Harnett County Government Complex
307 W. Cornelius Harnett Boulevard
Lillington, NC 27546

RE: Blue Agave Mexican Grill

A plan review application was received by this office concerning the construction of the above referenced facility. The application is not approved at this time. Additional information is needed and is detailed below:

SHEET NO.
F-2 OF 3

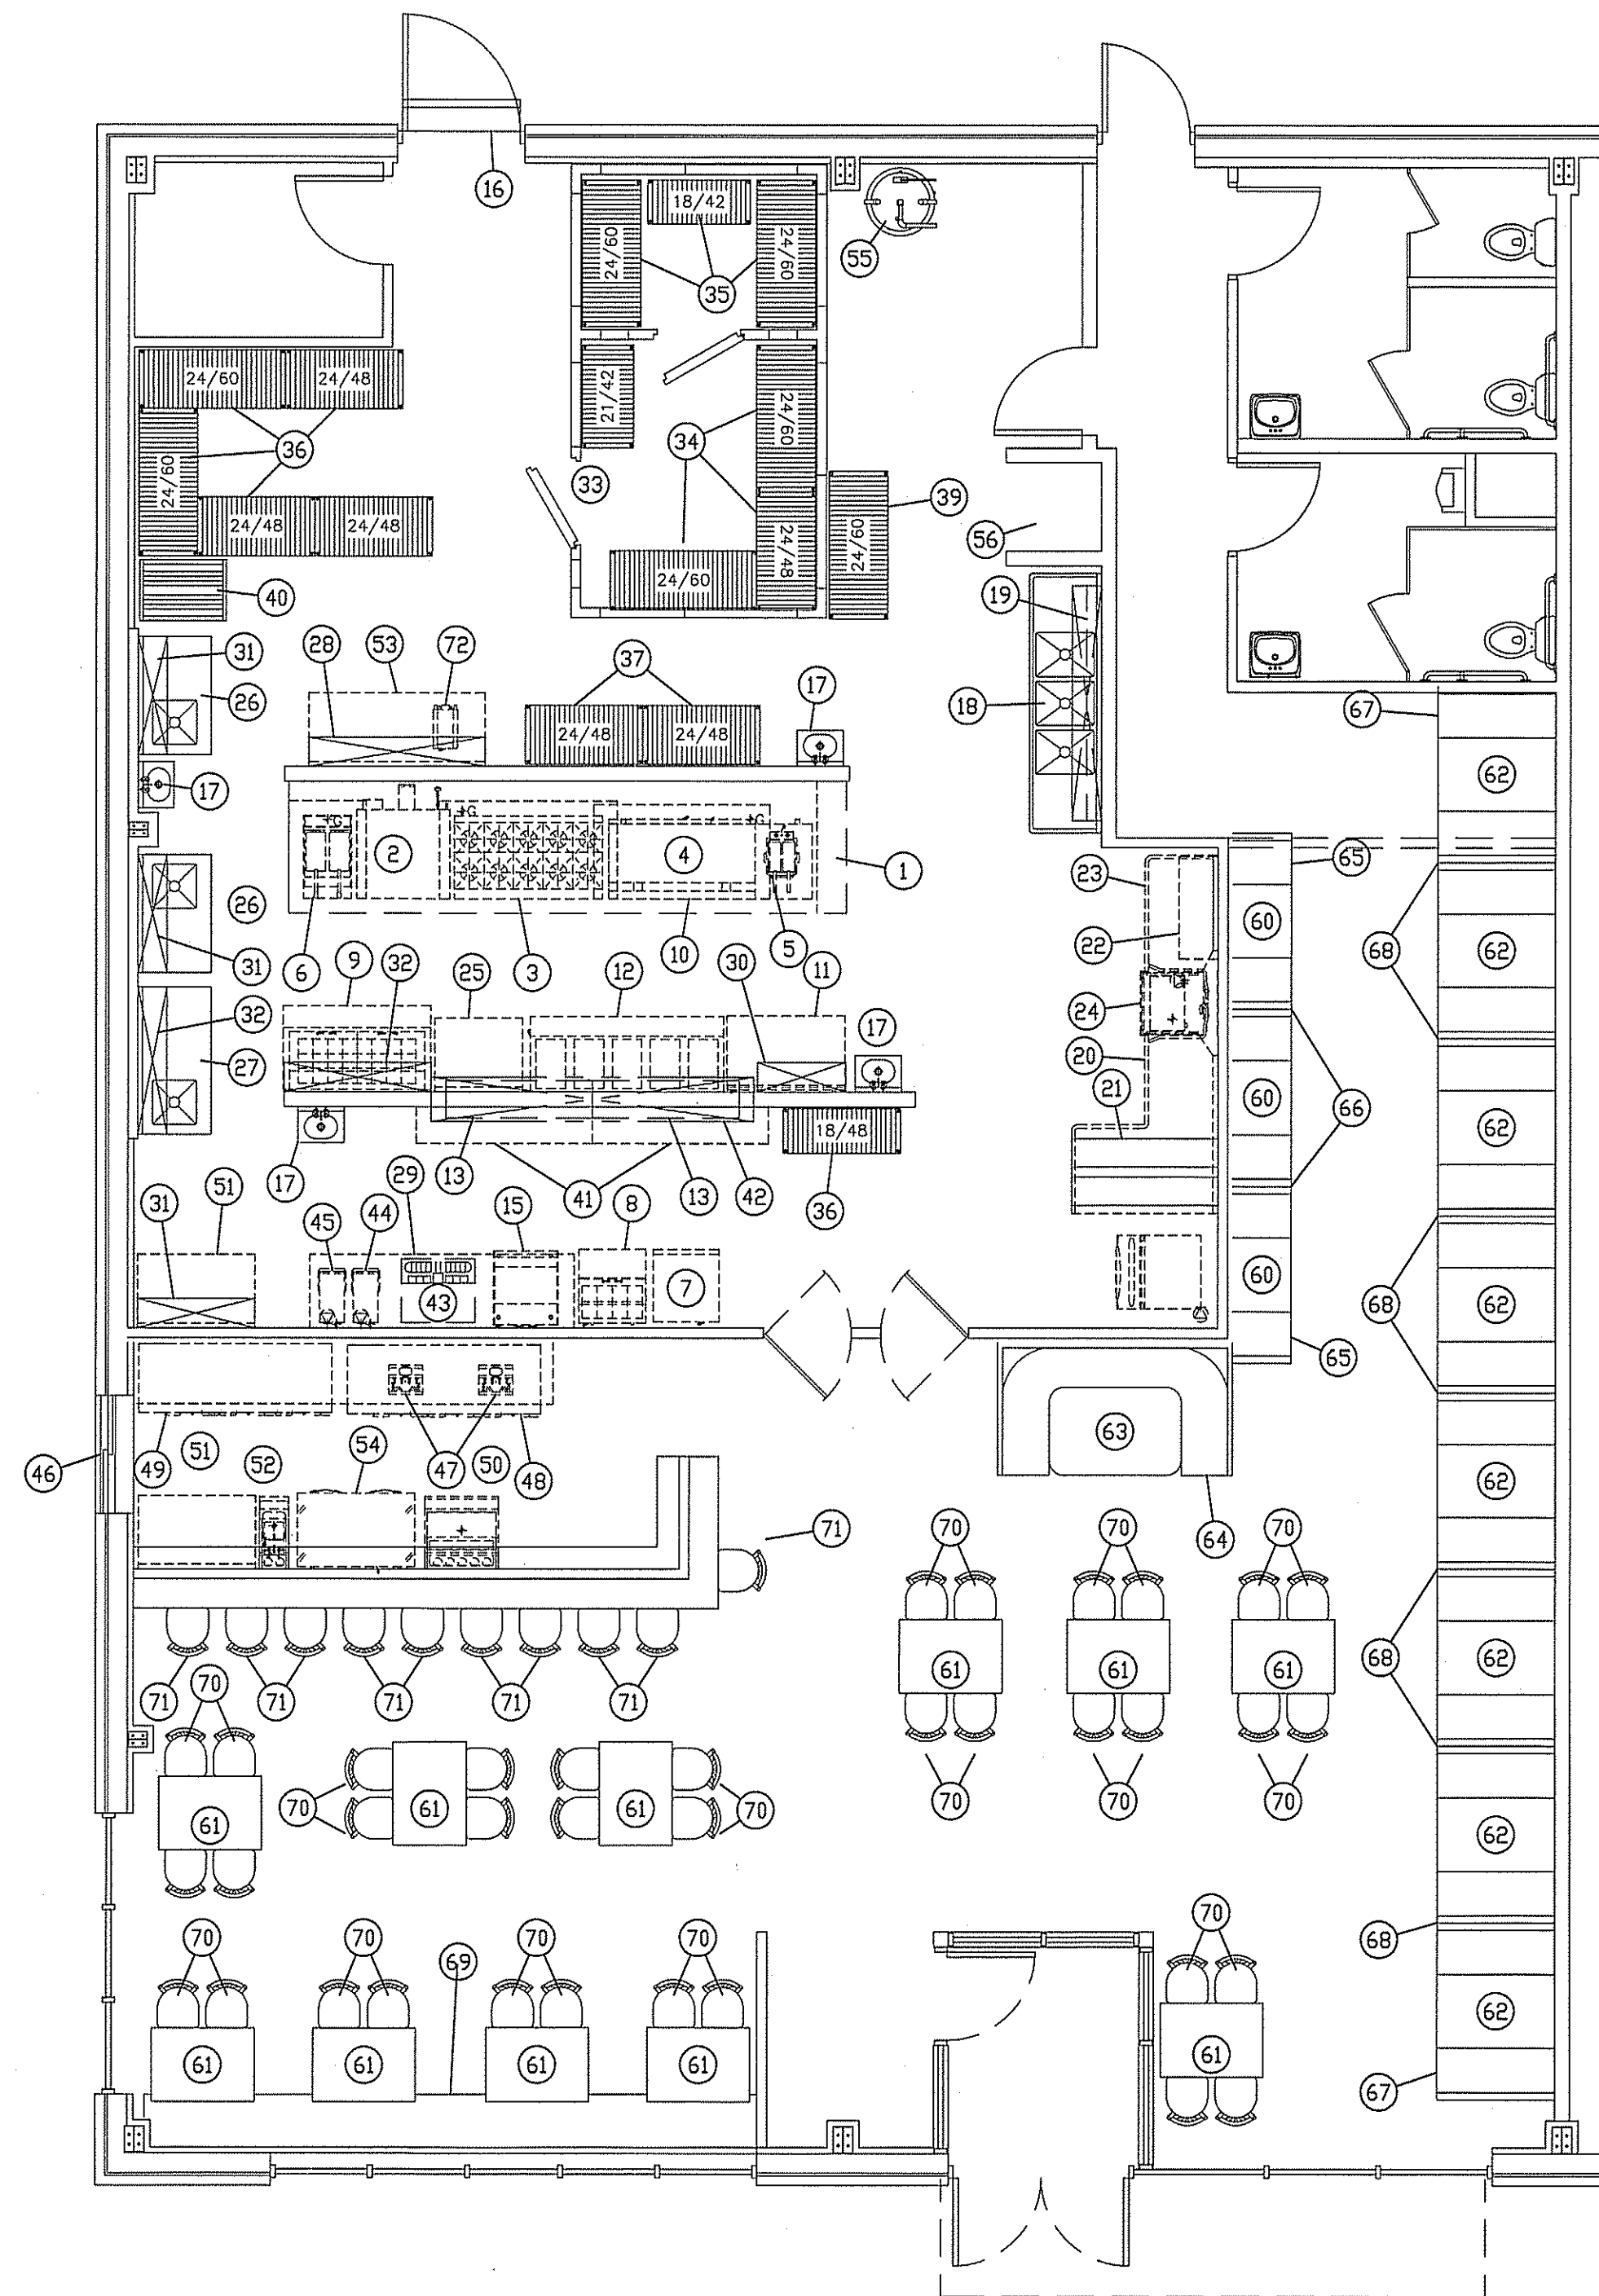
- A complete set of equipment specification sheets to correspond to items listed in the equipment schedule on page F2 of the plans was not submitted.
- A proposed menu was not included.

- Will a prerinse sink/sprayer be provided at the dish machine?
- Will kegs be stored in the walk-in cooler? Where will empty kegs be stored?
- Please describe use of #72, power drive unit.

The can wash is located in close proximity to a clean utensil shelf and three compartment sink. Ideally, the can wash would be located outside the back door. This would minimize potential cross contamination and open up area for additional shelving. If this is not feasible, then perhaps it could be moved to the back corner of the room beside the water heater. Please indicate if you would consider moving the can wash to a more appropriate location.
